About the application

Application number: 2020/90667	
What is the application for?:	Formation of entrance porch and outdoor terrace, internal refurbishment, replace
Address of the site or building:	Farmers Boy Inn, 44, Marsh Lane, Shepley, Huddersfield, HD8 8AP
Postcode:	EH12 9JZ

User comments

client					
STAR PUBS AND BARS					
address					
THE FARMERS BOY 44 Marsh Ln Shepley Huddersfield HD8 8AP					
drawing title					
PROPOSED GROUND FLOOR PLAN					
drawing no	rev	date	drawn by	checked	scale @ A1
7724-02	a	21.05.18	LB		1:50

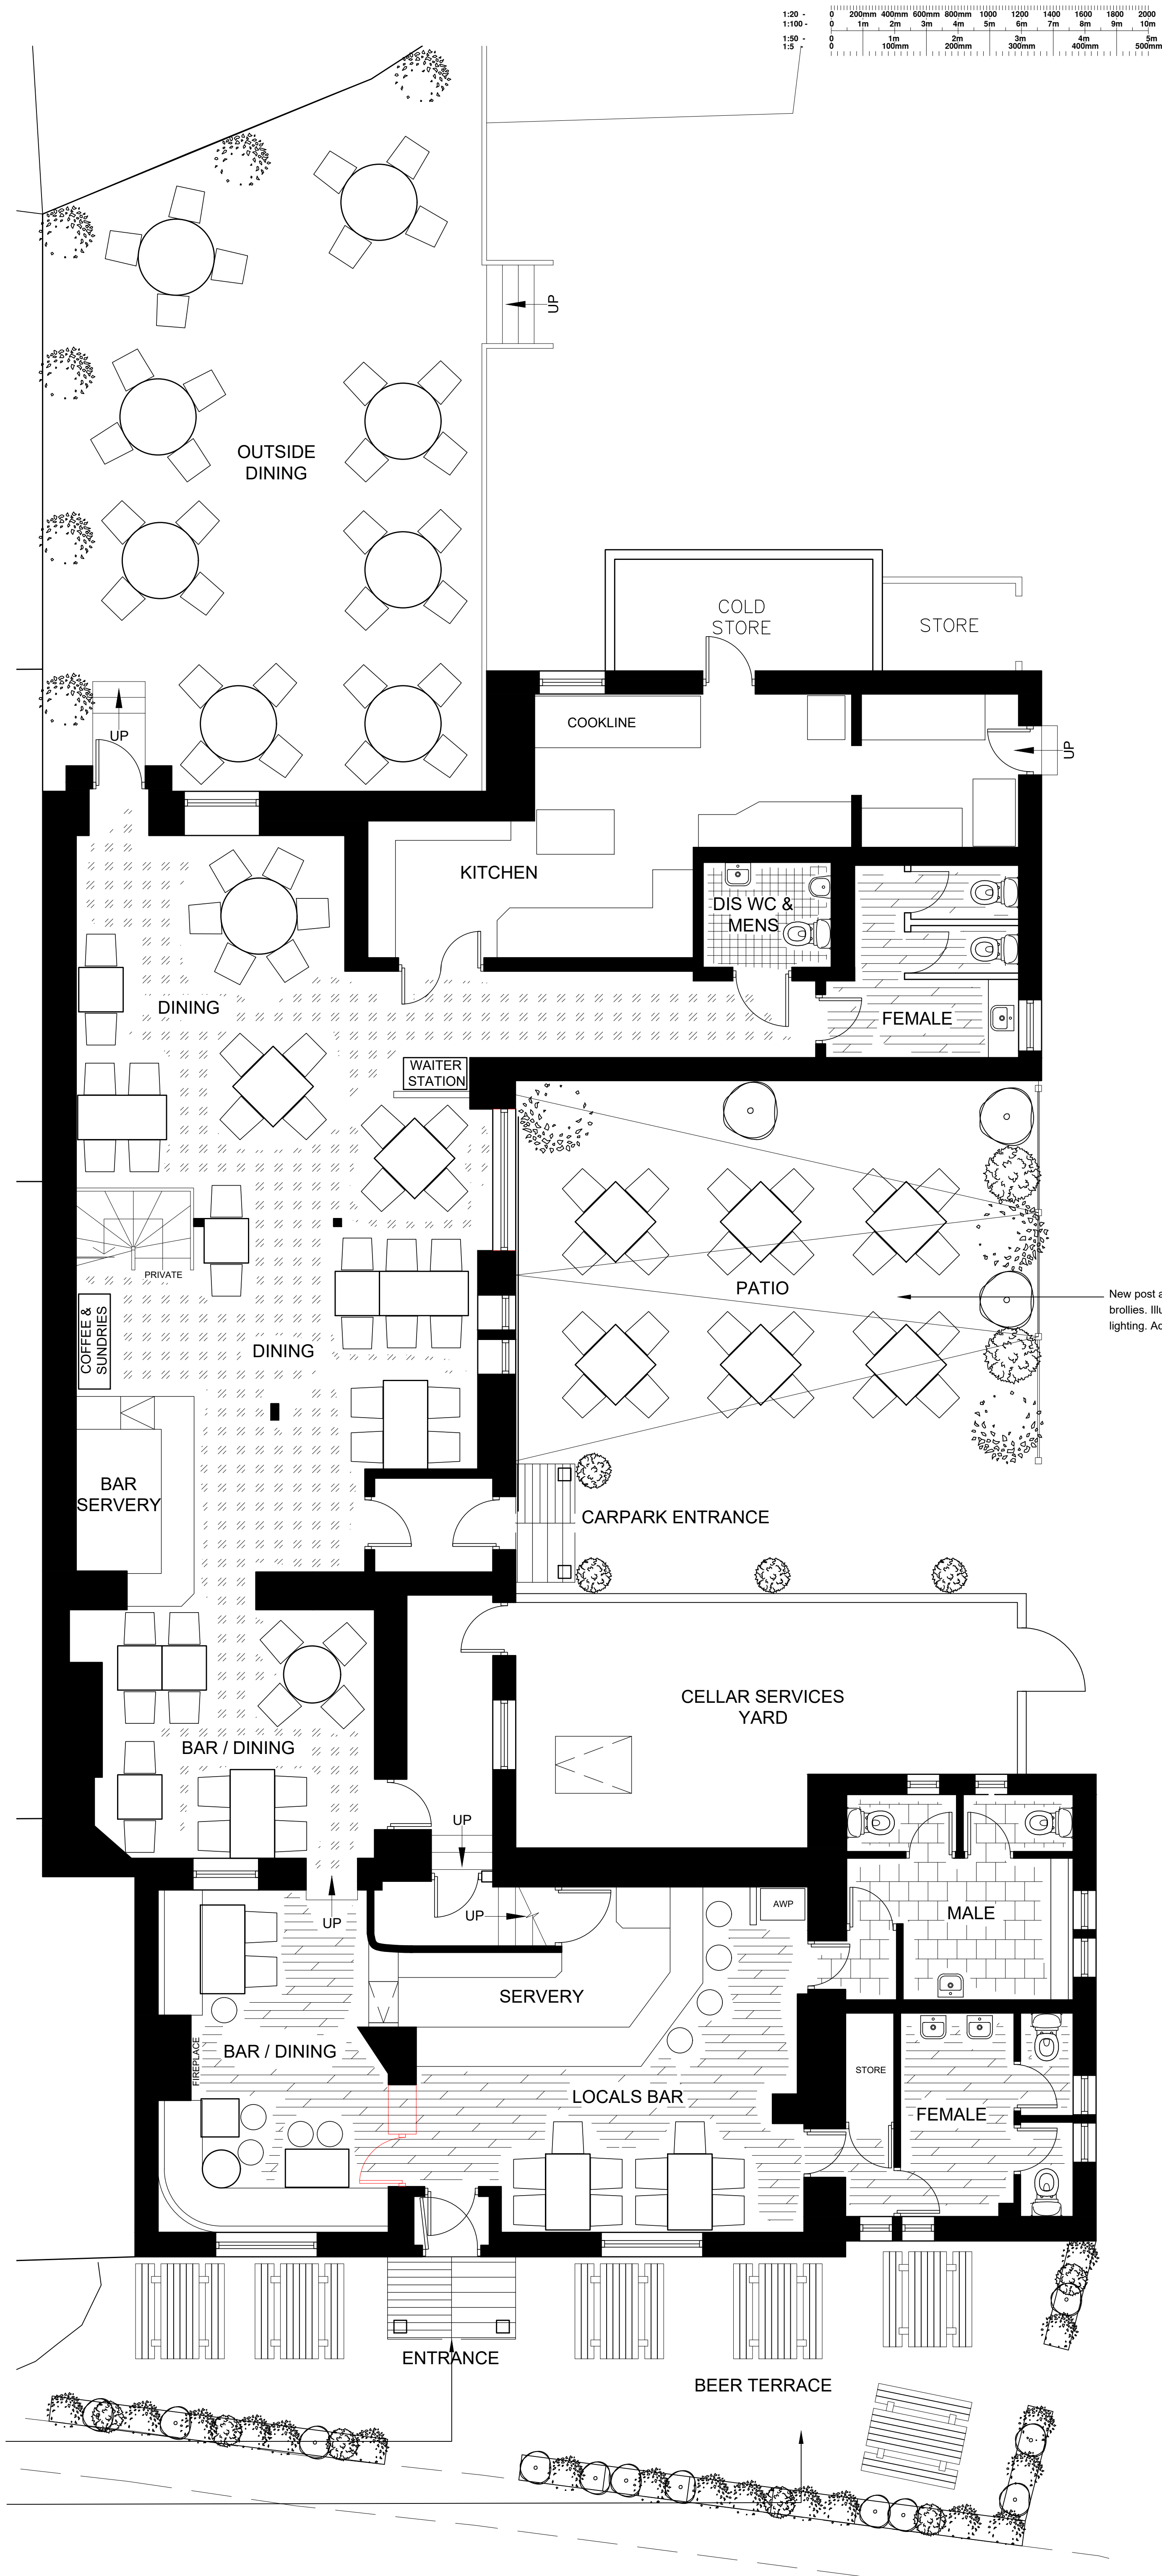
Type of comment: An objection
Although we are pleased that the Farmers Boy is due to reopen, we are very concerned that the application includes a large number of external 'covers' as we know from experience that it will mean an excess of noise, particularly in the summer months. As near neighbours to the pub, we have suffered before from shouting, bad language and anti-social behaviour. Excessive outdoor alcohol consumption in warmer weather has resulted in irresponsible parents allowing their children to do as they please. This has led to stones being thrown at nearby houses and passing vehicles. We have also had occasions when glasses have been deliberately smashed in the pub car park and in the middle of the road on Jenkyn Lane. We have witnessed several occasions when footballs have been kicked into Jenkyn Lane by children playing on the grass, then jumping over the wall to retrieve them, putting themselves and road users in danger. We really do hope that the number of outdoor tables is kept to an absolute minimum. Another concern is that the small car park will not be adequate for the potential number of customers, which will result in cars being parked on the narrow Jenkyn Lane, then people climbing over and damaging the dry stone wall. This will clearly have a negative impact on residents' parking. Thank you.
